**United Utilities Water PLC
Developer Services & Planning**
Thirlmere House
Lingley Mere Business Park
Lingley Green Avenue
Great Sankey
Warrington WA5 3LP

Your ref: 3/2012/0640
Our ref: DC/12/3313
Date: 11-SEP-12

Location: Land off Pendle Drive, Whalley, Lancashire
Proposal: Discharge of conditions

Drawing Title
Adoptable Drainage Layout

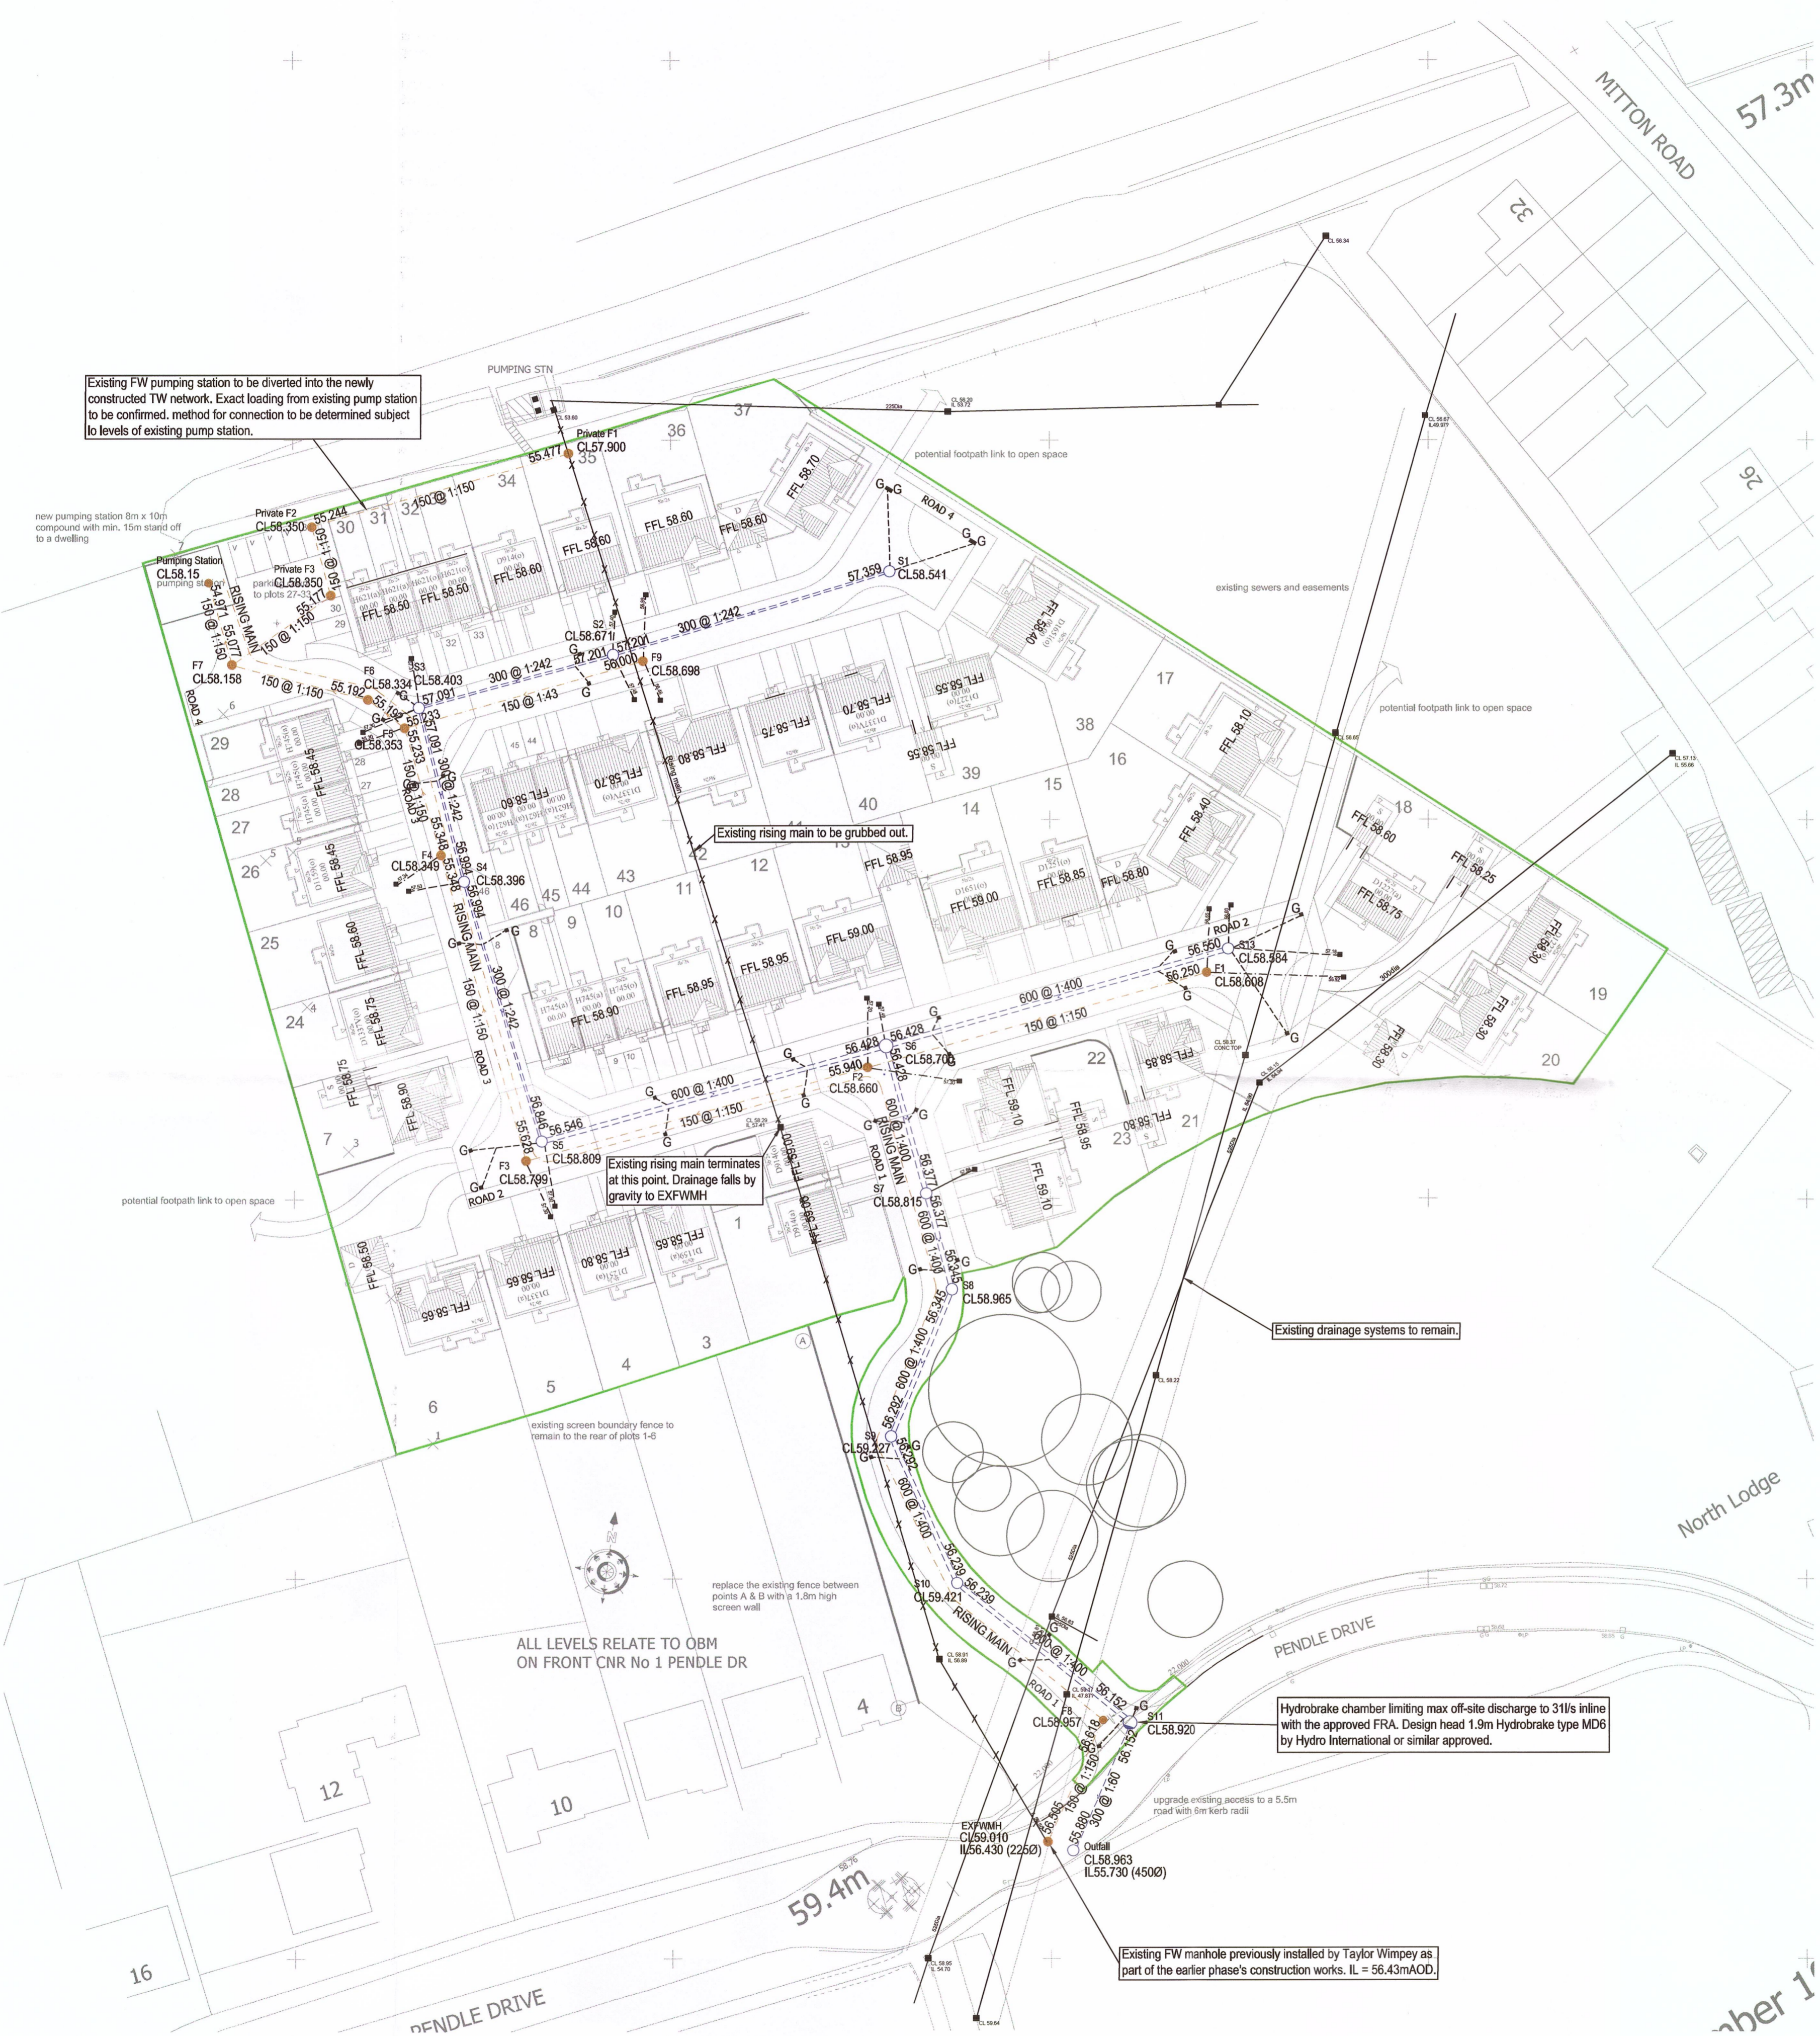
I am sure I have already commented on this one - please check before sending out
I can confirm that conditions 3 & 4 of the planning approval can be discharged providing that
the drainage principles outlined on Drawing 880209/01/Rev P3 are adhered to by the
developer.
